From: Michael Eastham
Sent: 13 November 2017 20:36
To: Fiona Fitzgerald
Subject: FW: BE/102/17/OUT

Further to the comments/queries raised by the EHO, please see comments in red below and attached.

From: Fiona Fitzgerald
Sent: 08 November 2017 14:19
To: Planning.Responses
Cc: Michael Eastham
Subject: BE/102/17/OUT

2B: With Acoustic Barrier L_{AMAX}

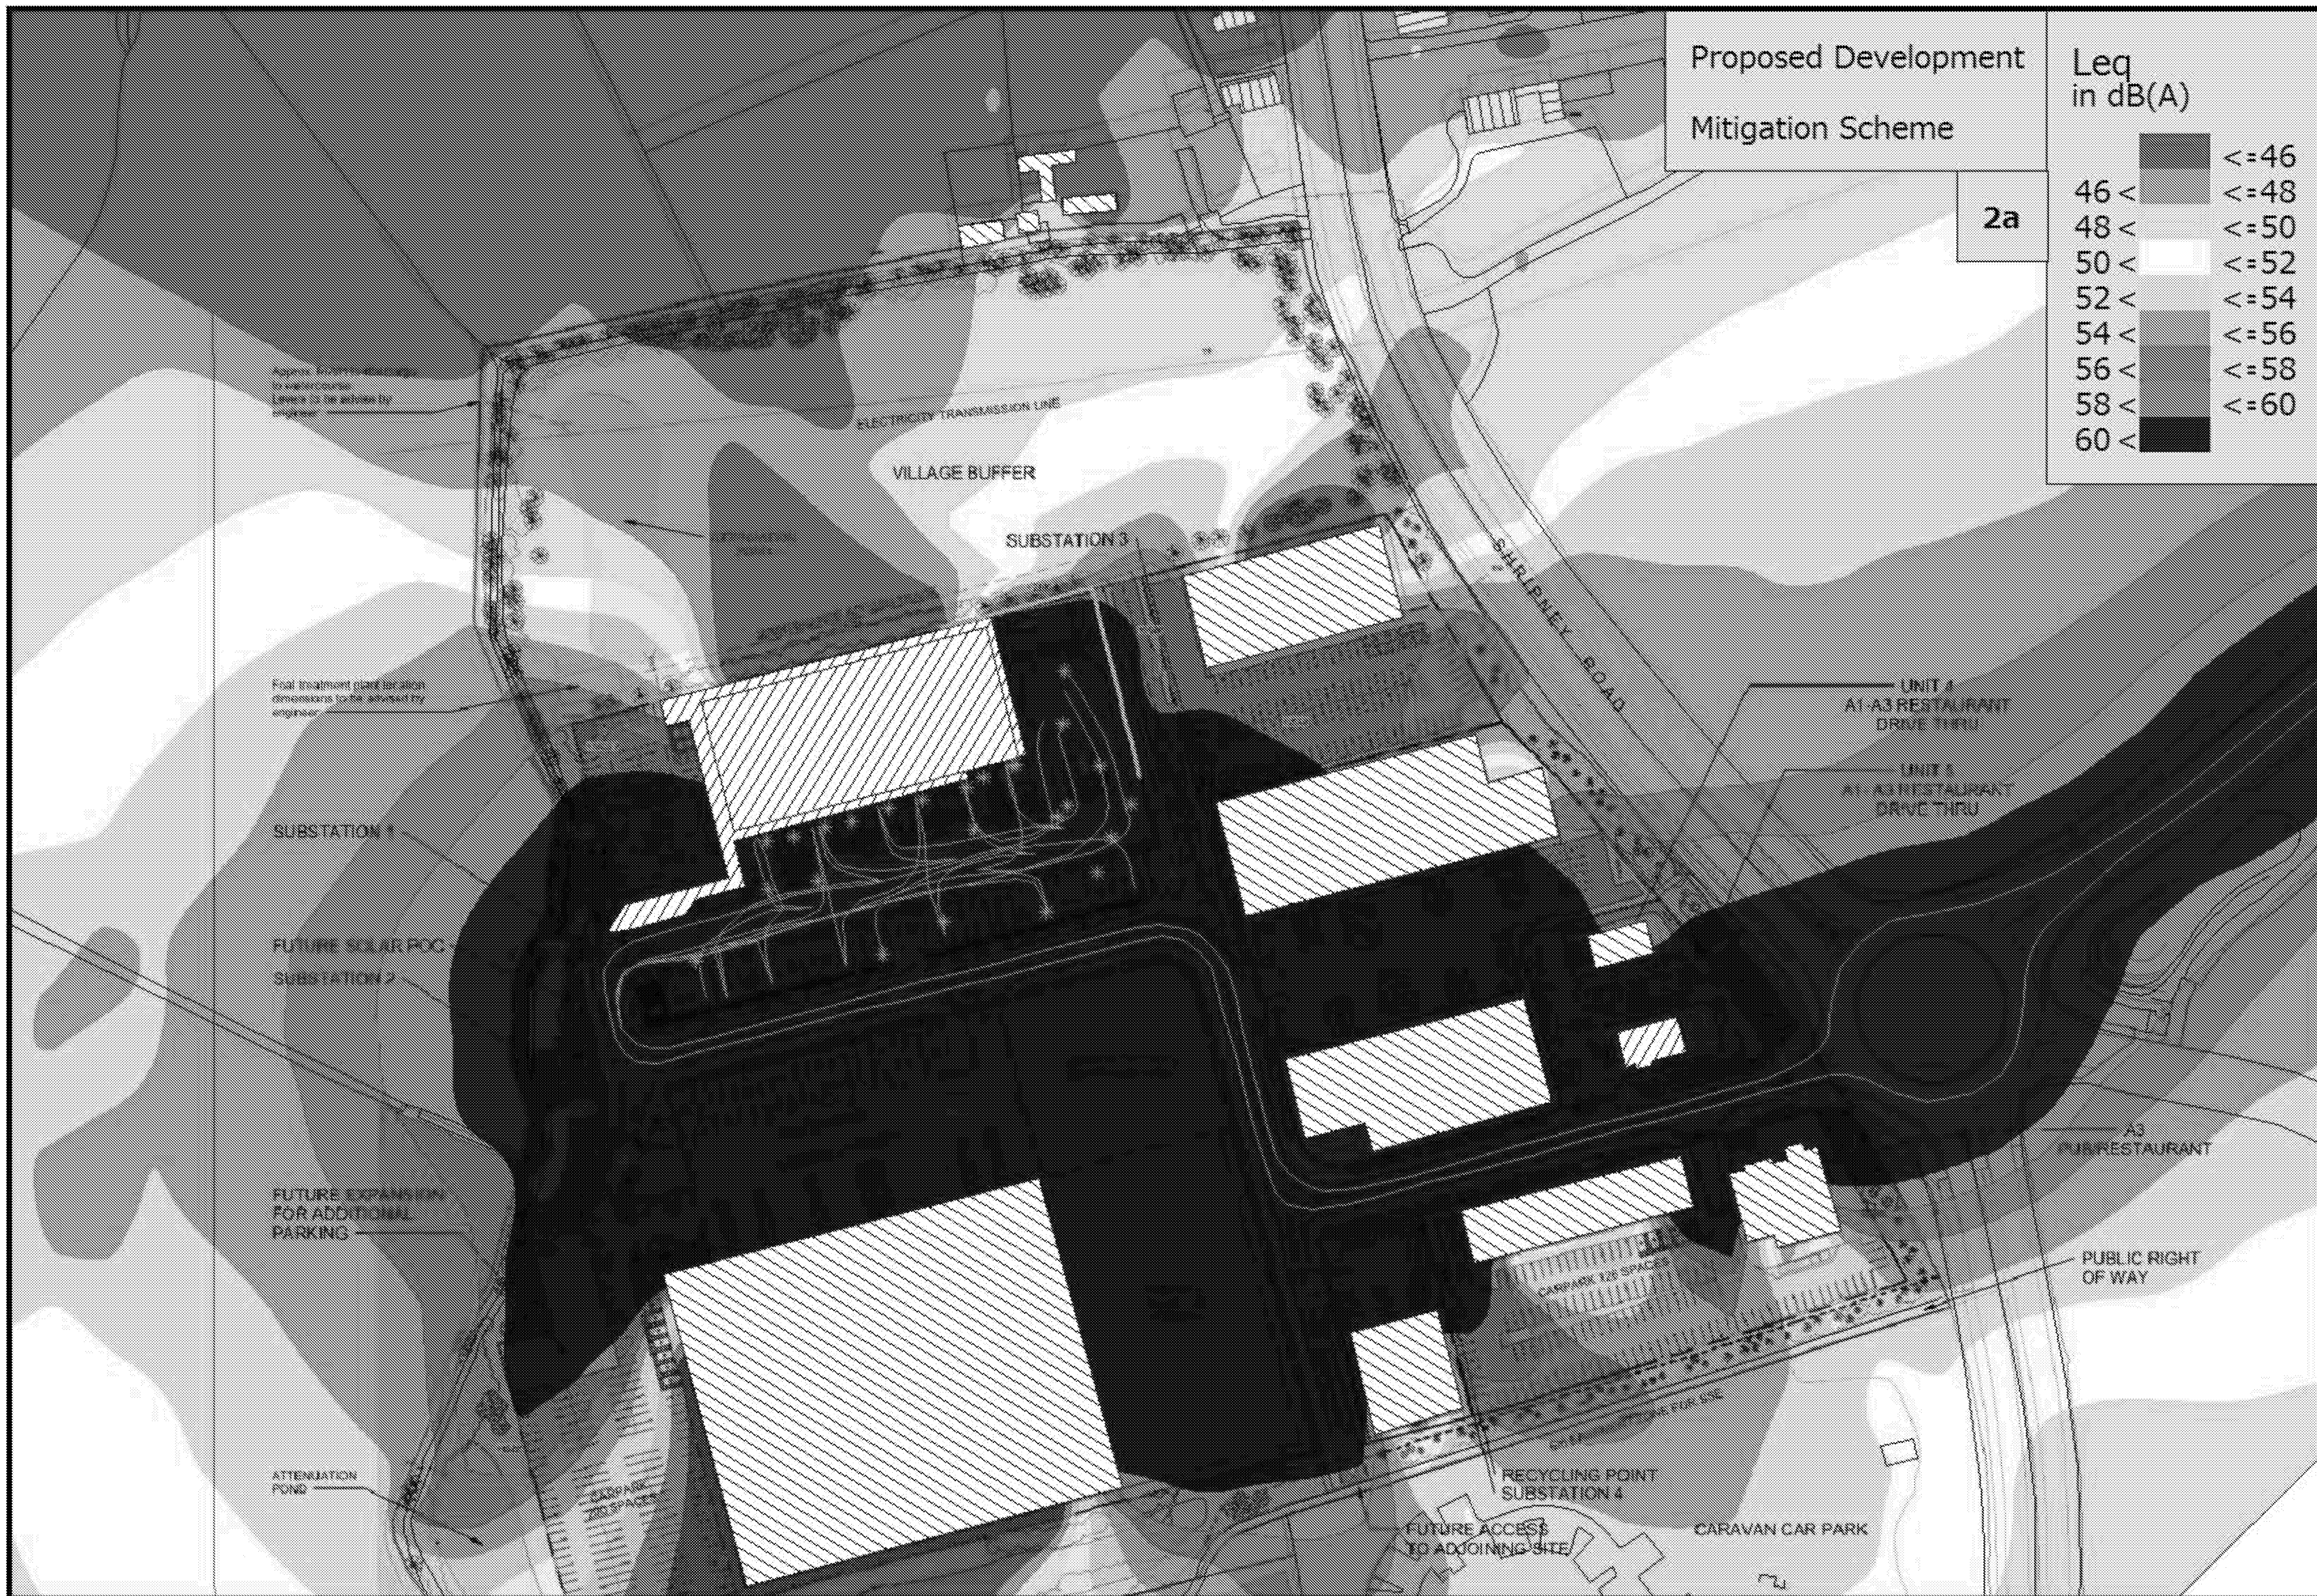
1. The report only deals with noise in detail for Unit 2 and whilst I understand this because the application is for full permission for Unit 2 and outline for the rest of this site, I have concerns that there may be cumulative noise impacts as unit 1, 3, 6 and 7 also either be B1/B8 use and they may have associated HGV movements. I am concerned that any cumulative noise impacts have not been taken into account at this stage and wants out my permission has been given may not be fully resolvable at that point. But the applicant confirm whether they have taken this into account or not?

4. Paragraph 4.5 on page 12, just to clarify, “all loading bays“ means all loading bays in unit two presumably?

Unit 2 was assessed as the only full application. There is no detail relating to the future use of other units, although the assessment was modelled using worst case of all loading bays being operated simultaneously. Any future HGV movements across the site would need to double to give a 3dB increase. Even with this unlikely level of activity the L_{Aeq} levels at the nearest residential property to the north would be in the region of 51dB and still be within desirable WHO guidelines for external noise. Any L_{Amax} levels would be consistent with predictions.

All loading bays in Unit 2

REVISIONS	DATE	DRN	REV
MINOR EXTERNAL AREA AMENDMENTS (LANDSCAPE / FOOTWAY - UNIT 2)	08.08.17	HA	A

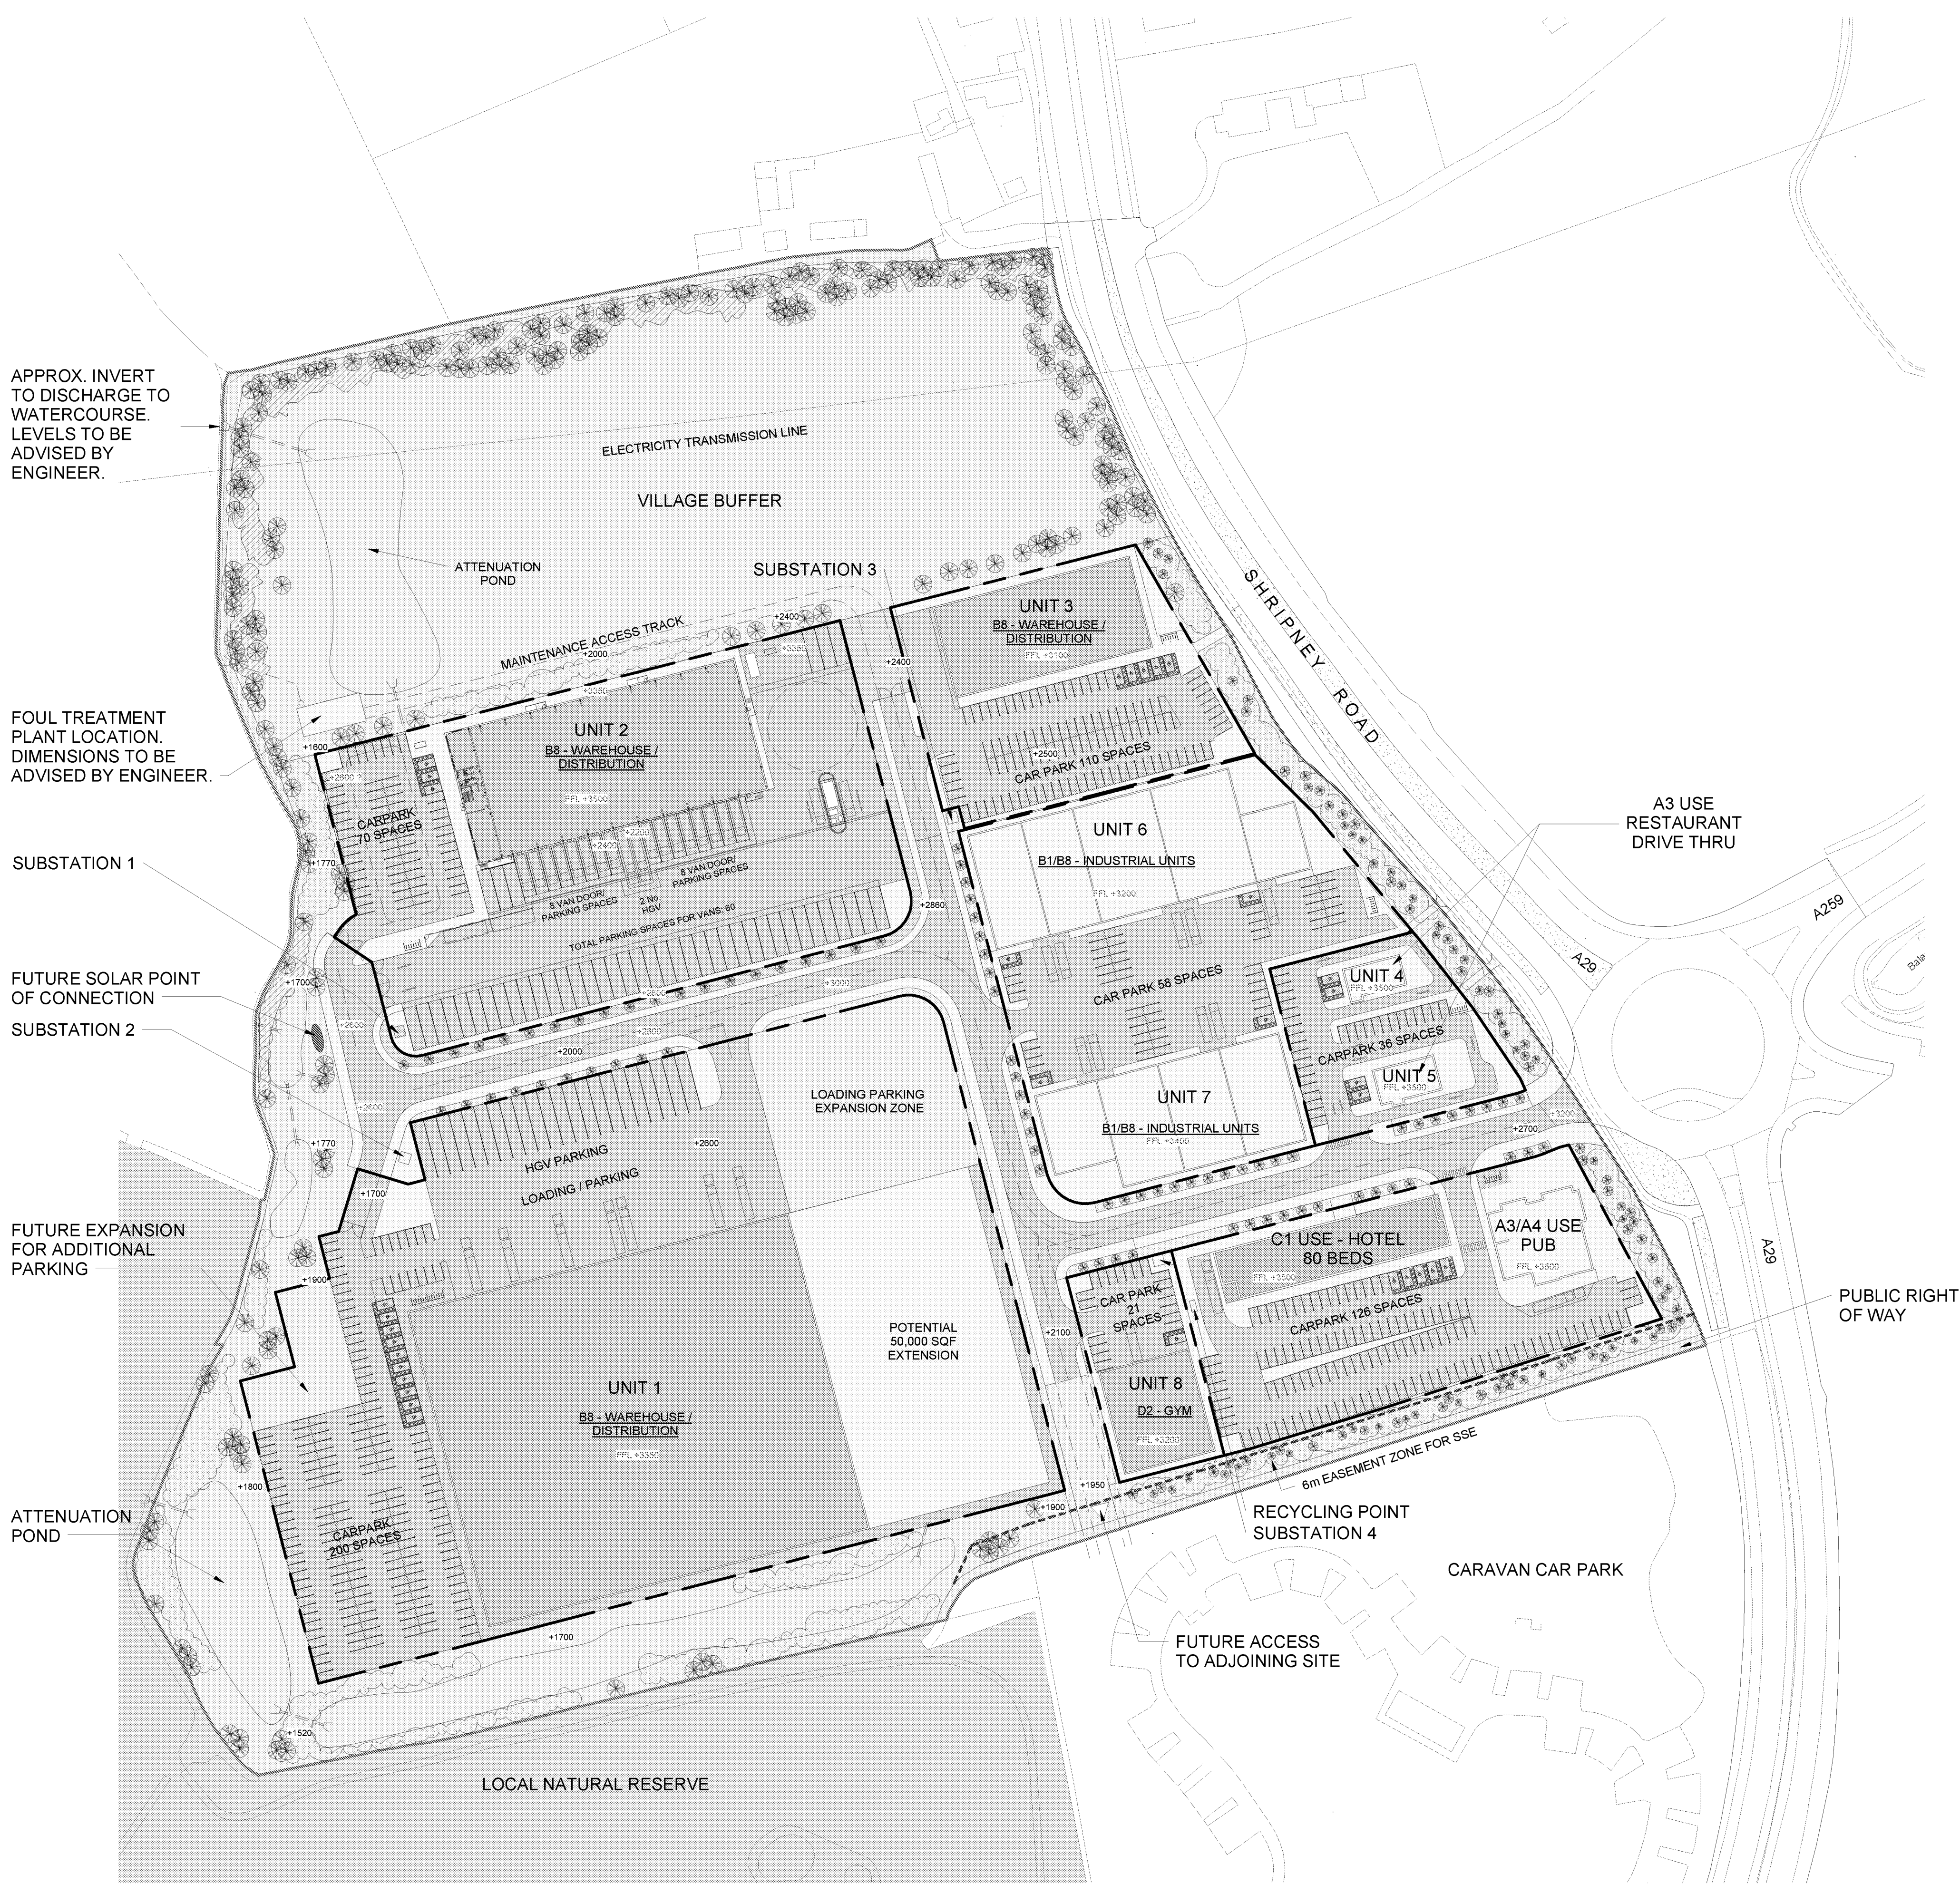
6. Paragraph 4.21. This states that a level dock loading bays will be sited at the northern elevation. Does this mean loading to and from HGVs will take place facing north i.e facing the Shripney Road properties? If so paragraph 4.23 cannot be consistent with paragraph 4.21. If the loading bay is at the north by definition the doors will have to be opened and closed frequently for accurate access and egress of product so acoustic performance of the warehouse structure cannot rely on the doors being closed. However looking at the plans it appears that the loading docks will be on the southern elevation. Please could the applicant clarify?

Apologies for the typo. As per the plans, all loading bays are to the south of the site. There is no loading /unloading to the north. Para 4.21 should read ..”sited at the southern boundary”
